Item No. **Report of the Head of Planning, Transportation and Regeneration**

Address 103 HILLINGDON HILL HILLINGDON

Development: Demolition of an existing outbuilding and erection of a 2 storey office outbuilding, including 2 parking spaces.

LBH Ref Nos: **2699/APP/2021/2808**

Drg. No. 21/3421/104
Scale 1:100
Date 20/05/21
Drawn by SB

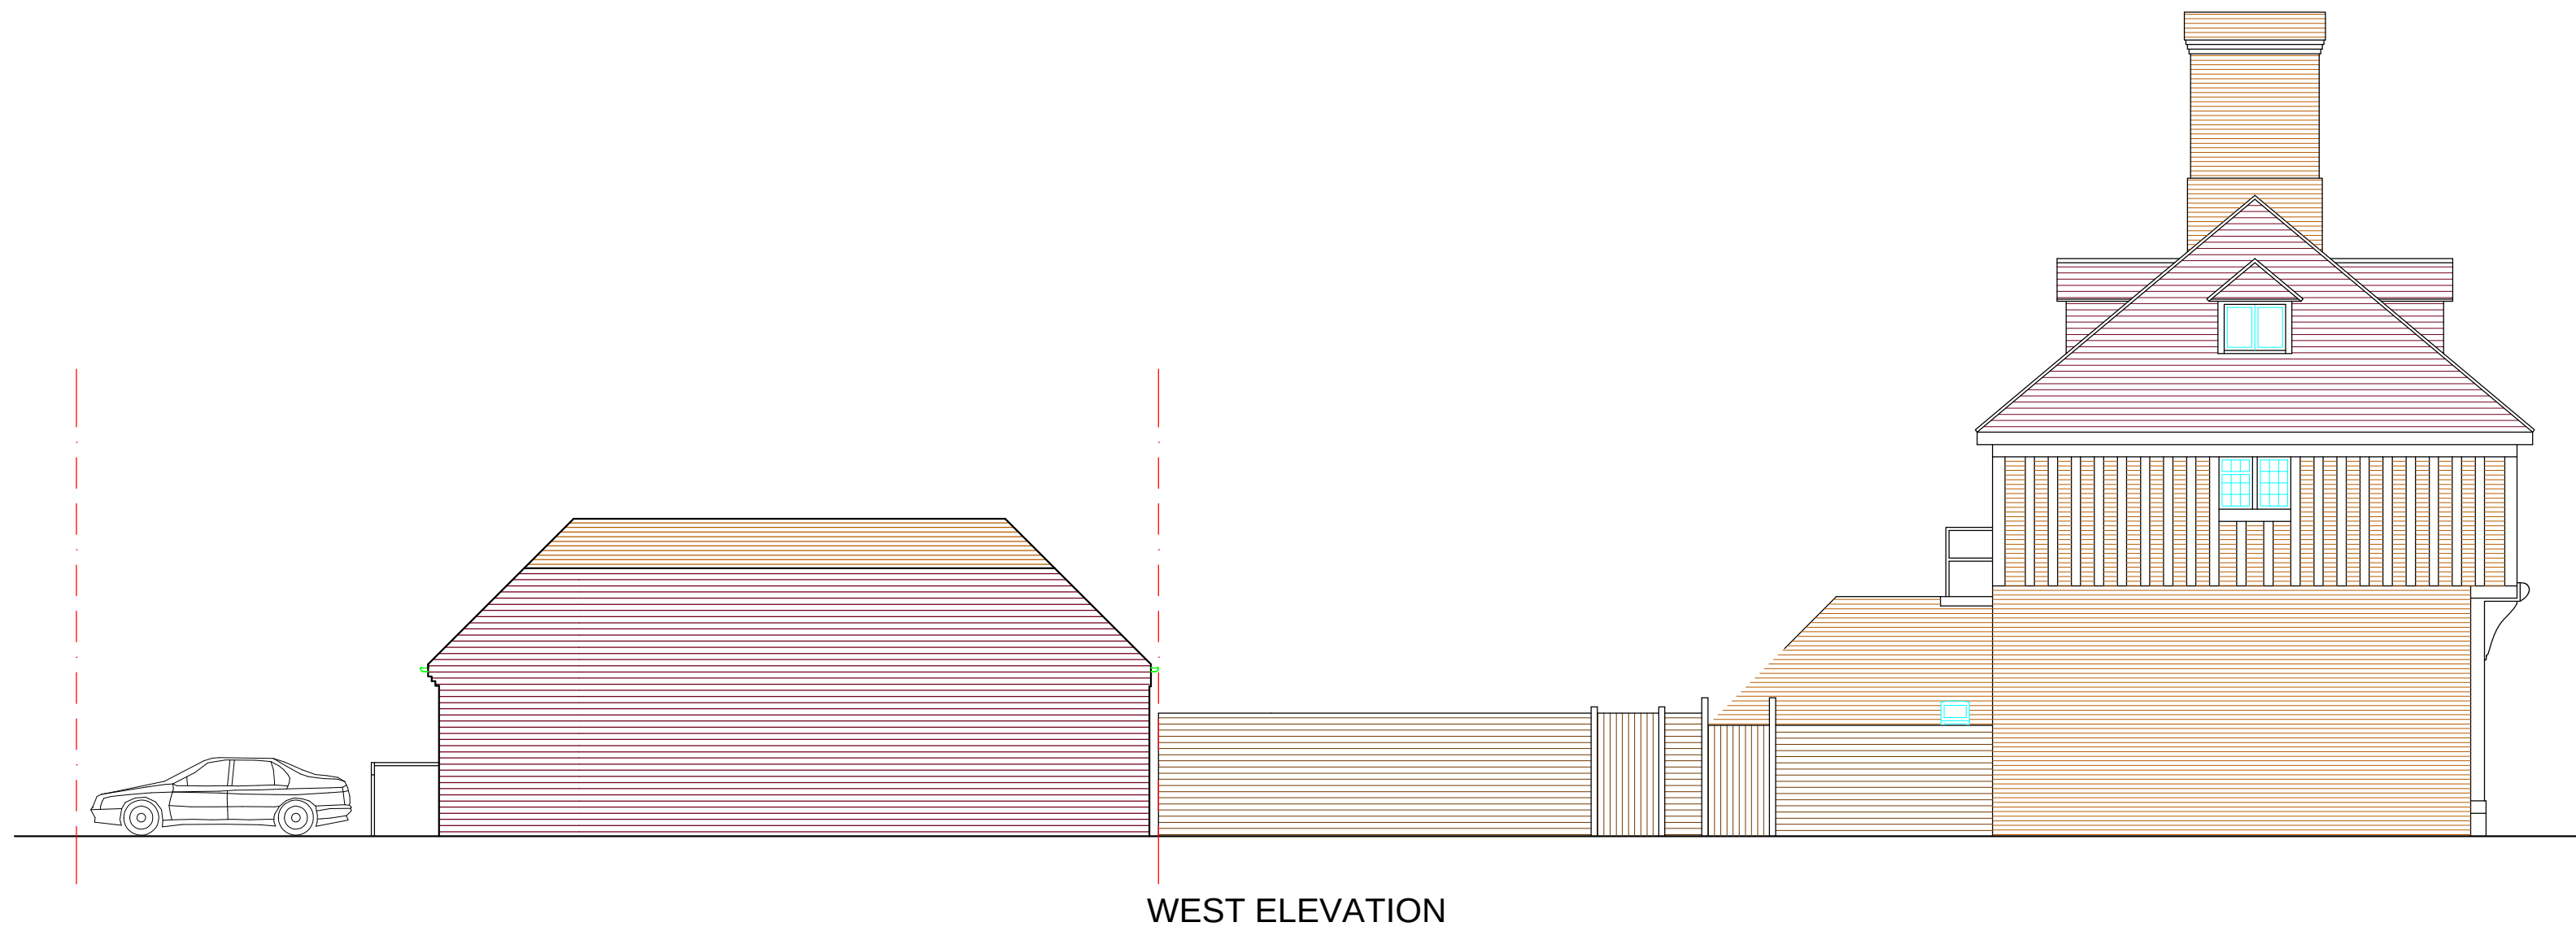
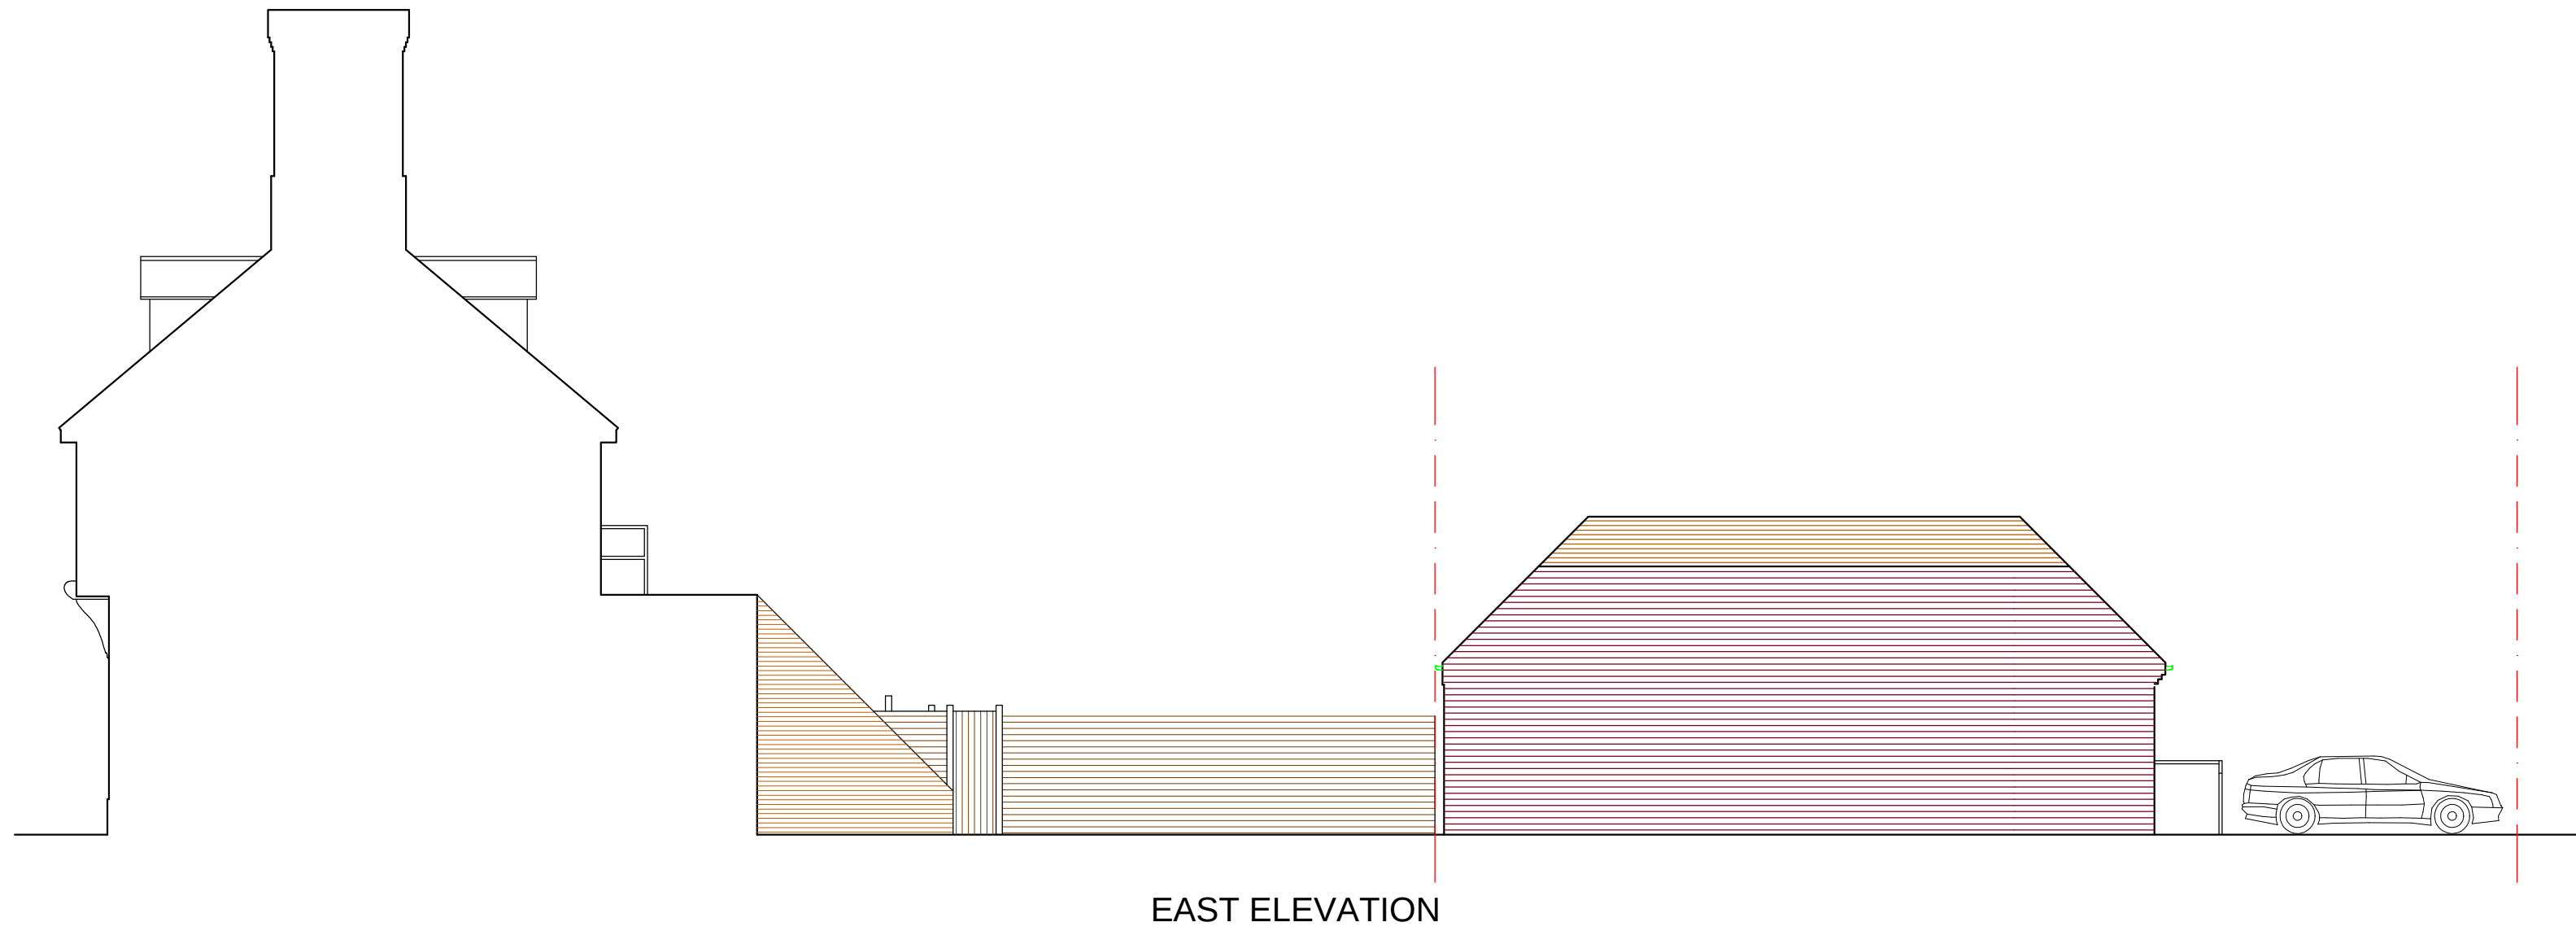
Whilst the proposal would continue the precedent set by neighbouring sites it is duly recognised the height of the building has been kept to a minimum by the inclusion of a crown roof form. Crown roofs are not a characteristic feature of the conservation area therefore, it is recommended that the roof is amended to a fully hipped roof.

The proposed box dormer would be considered an incongruous feature, appearing overly top heavy along the north elevation. The dormer would need to be reduced in width with the size of the window opening matching the windows below. There may be scope for two individual dormers along the rear roof.

The proposed office building would be approximately 11.5m deep and 5.15m high at its ridge. It would have 4.3m high parapet flank walls finished in brick.

Notwithstanding the above, the building would be between 5m-6m away from the first floor rear bedroom window of No.101A Hillingdon Hill. Due to its height and close proximity to the bedroom window, the building would appear as a dominant and visually intrusive form of development, which would lead to a significant loss of views and outlook from the room, whilst also causing a loss of light to the room. As such the proposal it is considered that the proposal would harm the amenities of No.101A.

Due to its height, depth, design and close proximity to the rear gardens of 105, 103A and 101A Hillingdon Hill the proposed office building is considered to form a visually intrusive form of development, which would lead to a loss of views from the mentioned rear

During the process of the application concerns were raised by the Borough's Conservation Officer regarding the design of the building. In response to the concerns the crown roof has been replaced with a pitched roof to integrate with the roof scape of the area, the height of the building has been reduced, the front dormer has been removed. The concerns raised have therefore been overcome. Additionally the one and a half storey building would be subservient to the much larger frontage buildings on Hillingdon Hill and be located along the rear service road, next to similar sized and larger buildings it would therefore be of an appropriate size and scale for its location (visually). It is also worth noting that buildings along the service road vary in design, as such the appearance of the new building would not be unduly harmful or out of character. Furthermore, the new building would be visible from Devon Way, however it would be partially obscured by landscaping at the end of the Devon Way cul-de-sac and would be sited next to other large buildings on the service road and is therefore unlikely to cause harm to the Devon way street scene.
